**SSD 8636: ENGINEERING & TECHNOLOGY PRECINCT DEVELOPMENT  
UNIVERSITY OF SYDNEY, DARLINGTON CAMPUS**

**UNIVERSITY OF SYDNEY RESPONSE TO SUBMISSIONS 2**

**9 DECEMBER 2018**

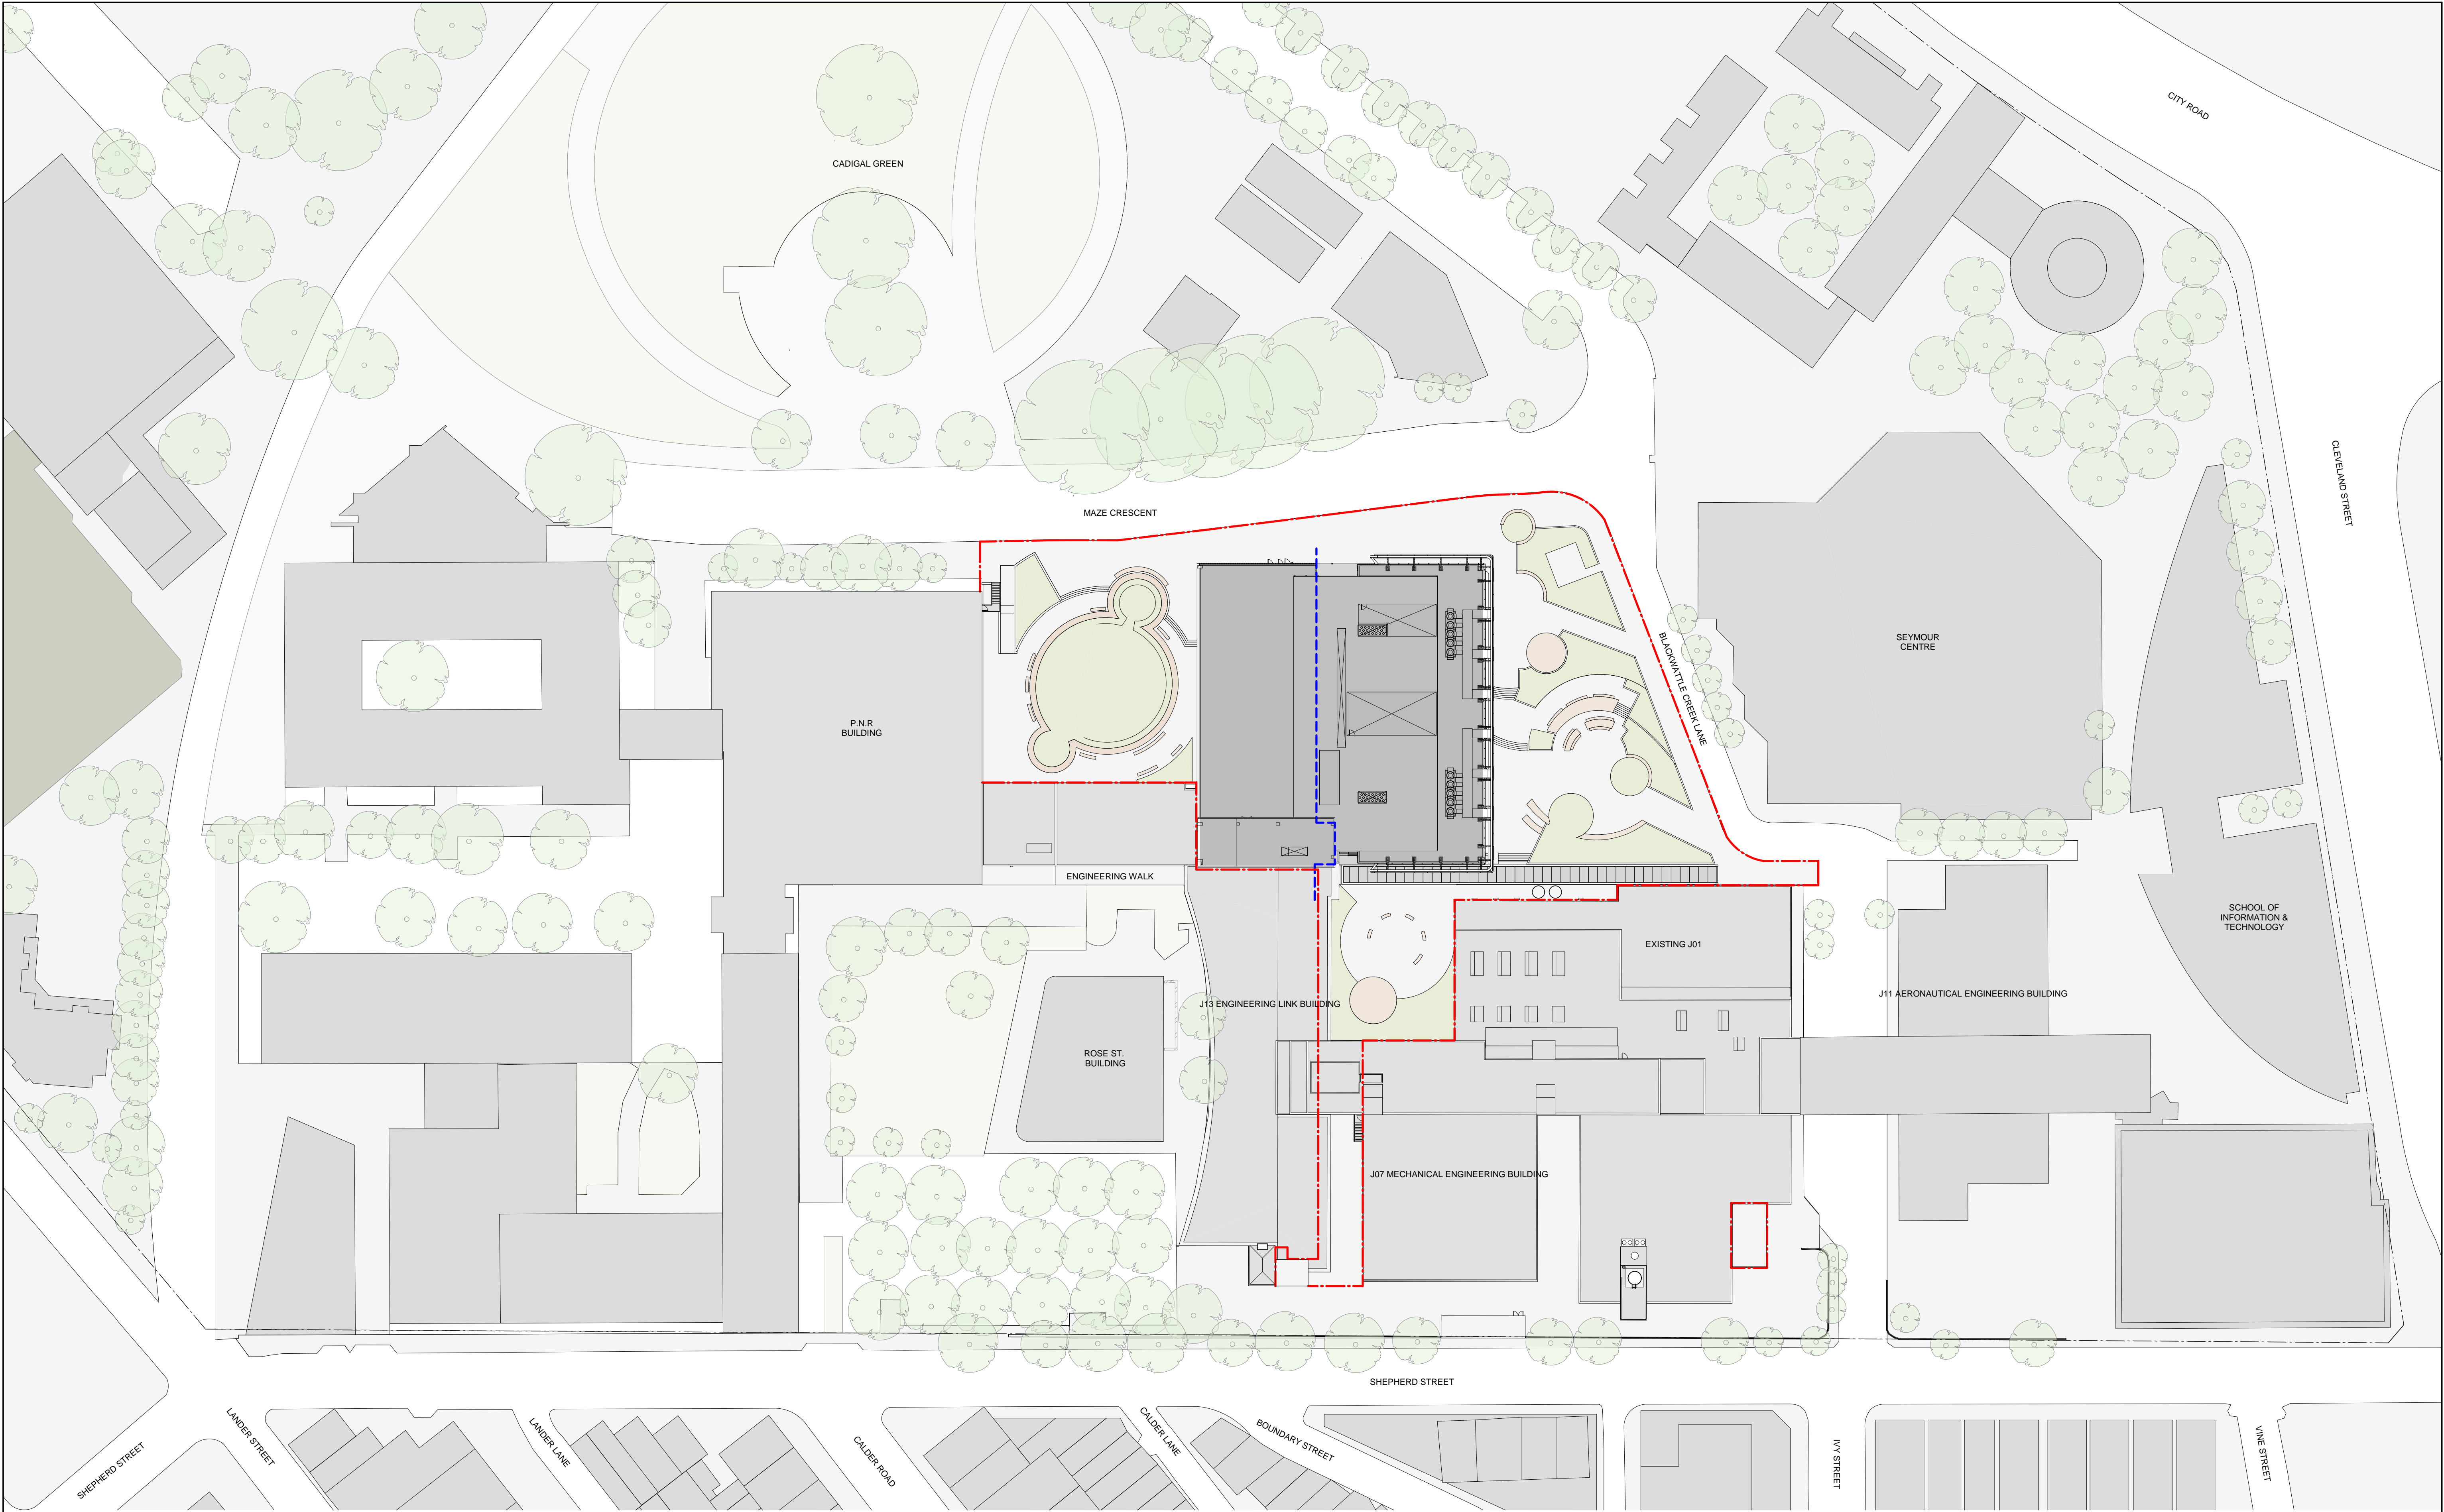
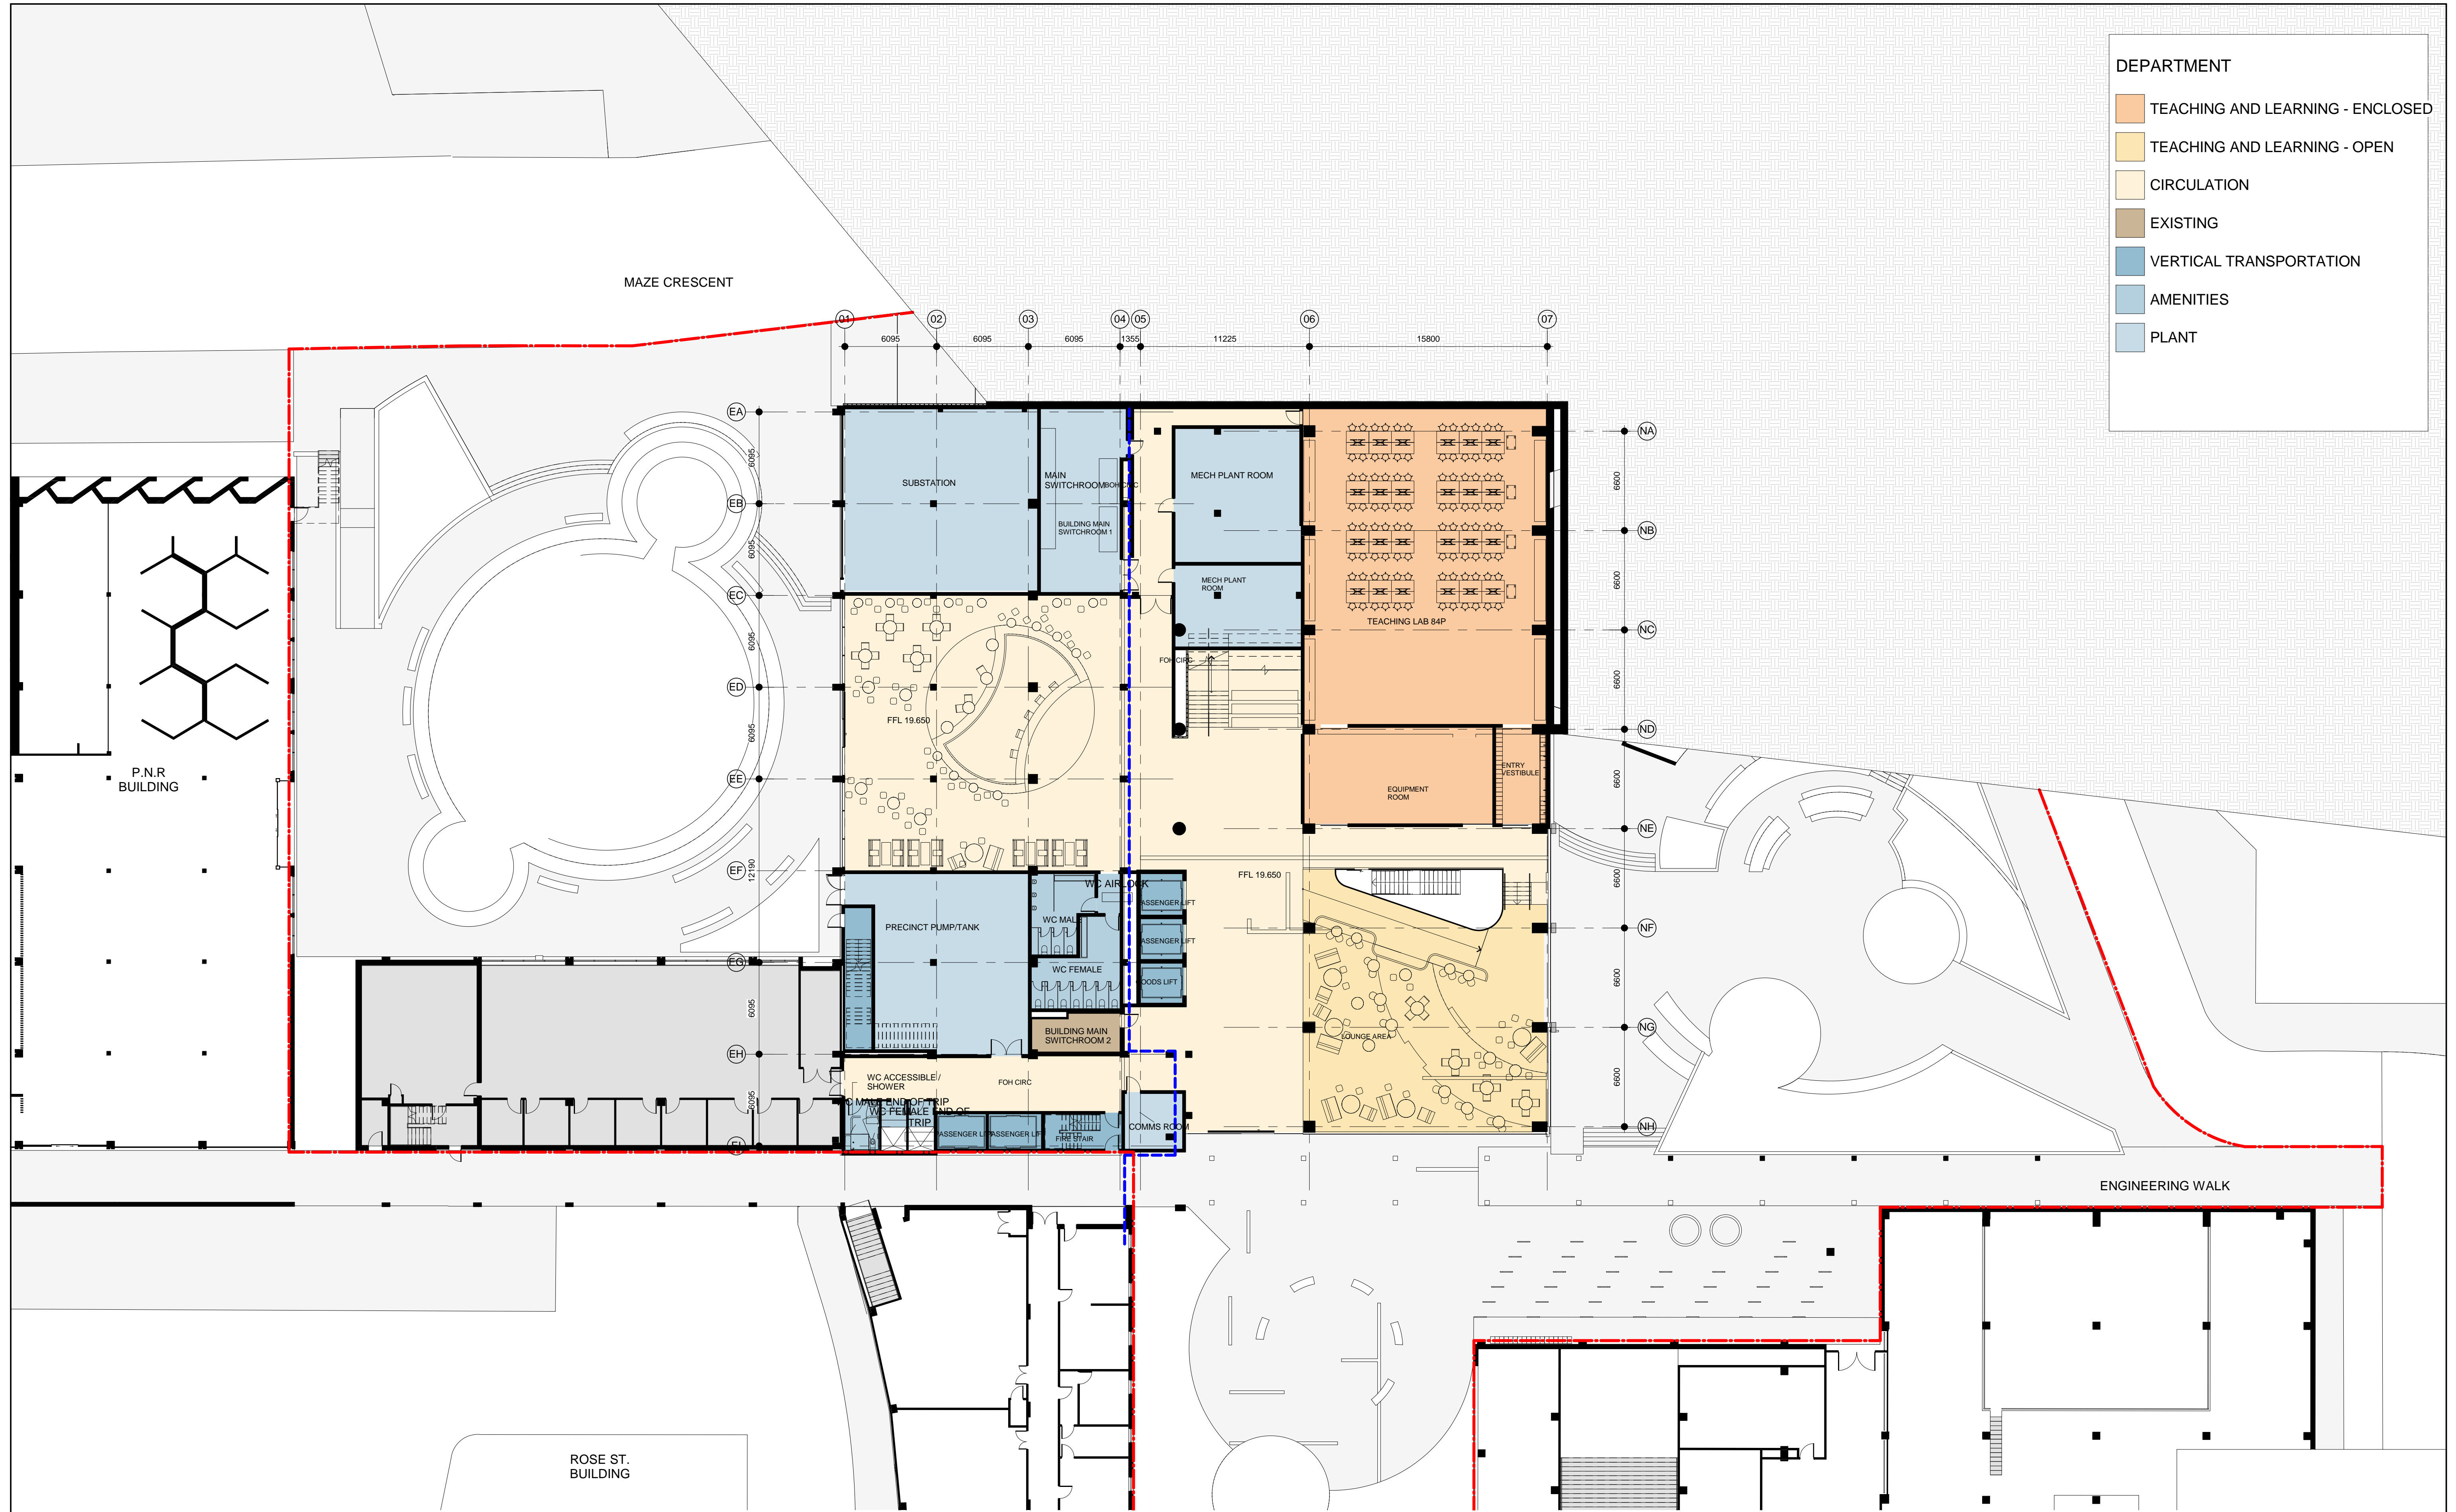
(xi) PHA Section 2.2.1 identified “Research NMR rooms” in Level 1. Provide confirmation if these rooms refer to both Nuclear Magnetic Resonance (NMR) laboratories Level 01, as shown in drawing A-DA-2101A.	The NMR laboratories are briefed to be capable of supporting NMR (Nuclear Magnetic Resonance) or similar research activity. The specific activities and apparatus within each room will be confirmed by the University when “research-ready” design definition is completed.
(xii) It is generally understood that NMR equipment uses cryogenic fluids, and the release/venting of these fluids are due to planned scenarios (maintenance, change of magnets, etc.) or unplanned scenarios (excessive heating of fluids while cooling magnets). Given that NMR equipment is located below ground and appears to be	The NMR laboratories are briefed to be capable to support NMR or similar low-EMR research activity. The rooms are designed to provide mechanical air supply and ventilation. More specific design will be dependent on “research-ready” design definition and advice from the University on cryogenic supply to apparatus and acceptable capture/ exhaust methods.

SSD 8636 – ENGINEERING & TECHNOLOGY PRECINCT DEVELOPMENT	
DPE KEY ISSUE	UNIVERSITY PROJECT RESPONSE
in a generally confined area, provide additional information on the safeguards (oxygen monitors with alarms?) to prevent asphyxiation-related hazards, specific to the operation of NMR equipment, including and not limited to the venting/ventilation design (equipment and lab room) and connection to DG storage cylinders/vessels (“gas bottles” adjacent to both NMR labs, as shown in drawing A-DA-2101A?).
